# CITY OF ALBUQUERQUE

January 15, 2016

**RE: Valle Prado Unit 3, ROFG  
Grading and Drainage Plan  
Engineer's Stamp Date 3-26-2015 (File: C09D011A)  
Certification dated 12-17-2015**

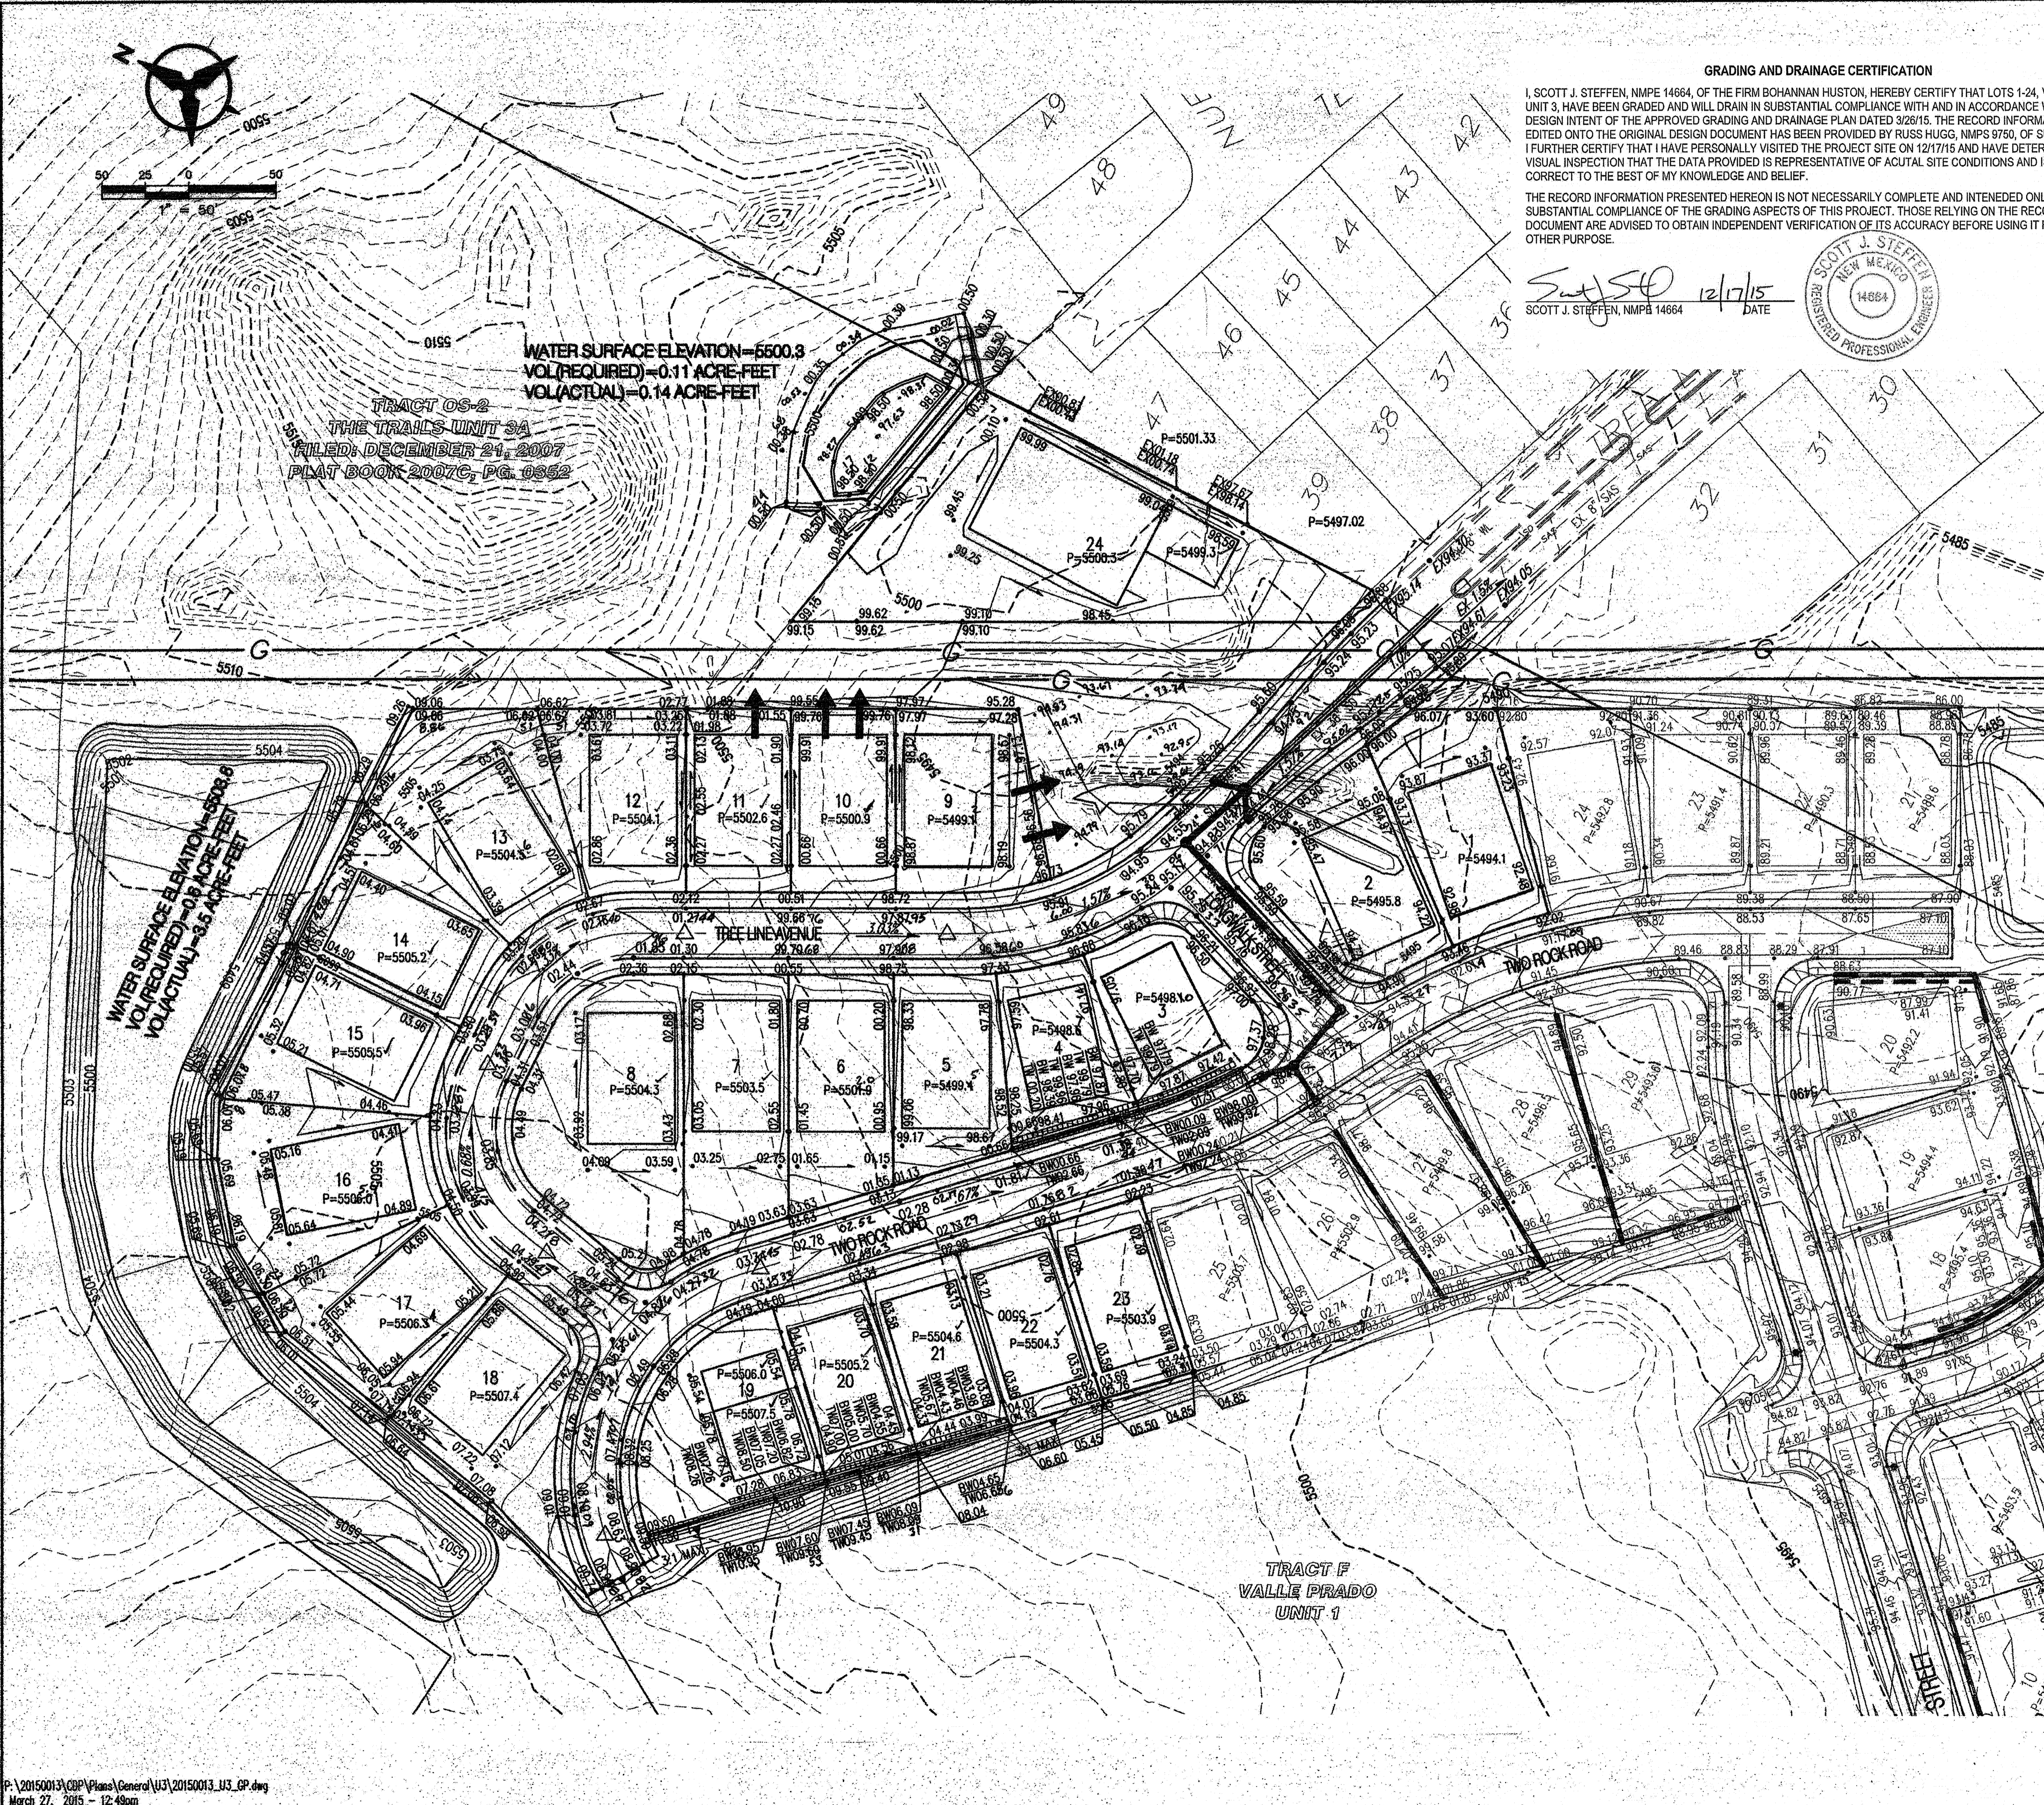
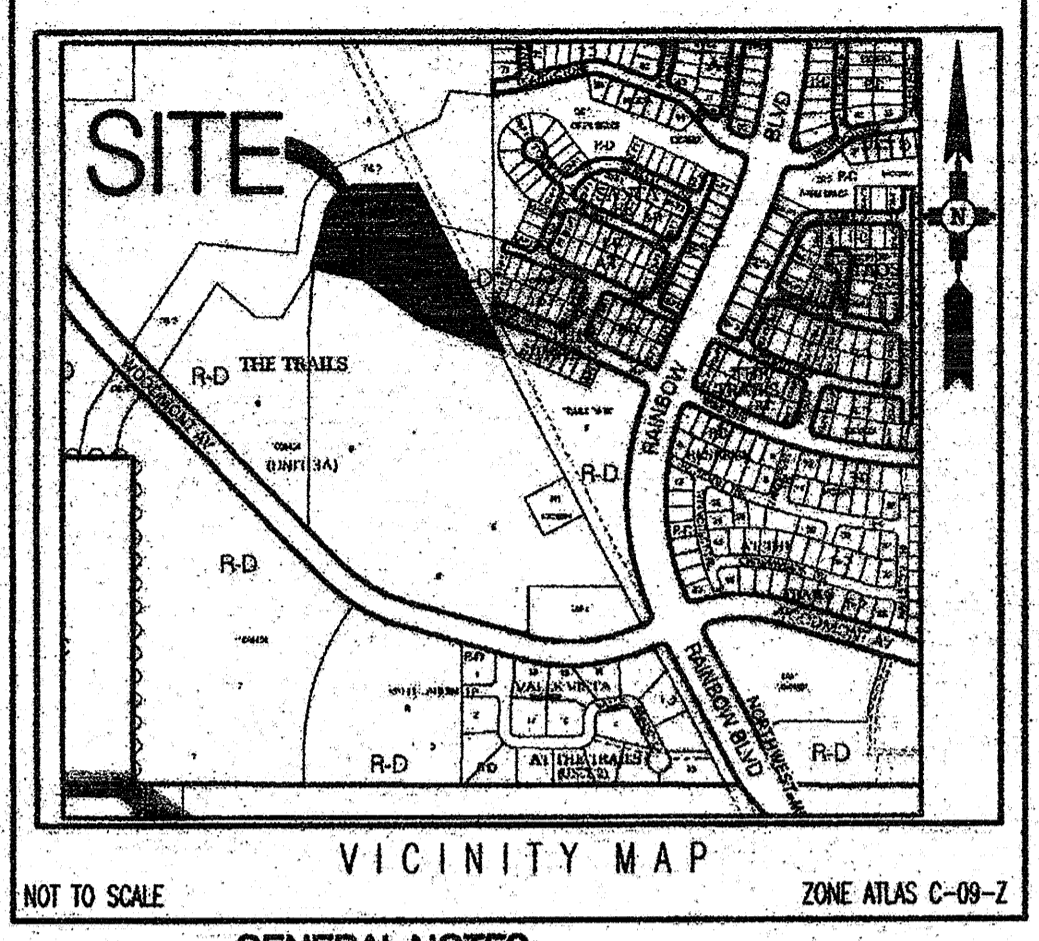
- A single Retaining wall on rear side of lots 3 & 4 must be built instead of the double garden walls. Slope grading cannot not be used on the lower side. A permanent retaining structure needs to be in place to hold up the ROW. A double garden wall lends itself possible changes by the homeowner which could possibly undermine support of the ROW.

- Double garden walls were allowed in lieu of retaining walls since they are allowed to retain 2 ft. However, since they are intended to function exactly as a retaining wall and support the grade and building pad, they must be built prior Release of Financial Guarantee.

- Note that using a single garden wall with slope grading on one side is not a viable solution since the sloped side will erode in time and undermine any capacity of the wall to retain. It will also reduce the cover and possibly expose the footing, causing freeze-thaw problems.

- The Alternative grading plan is not accepted since it does not show a viable drainage scheme.
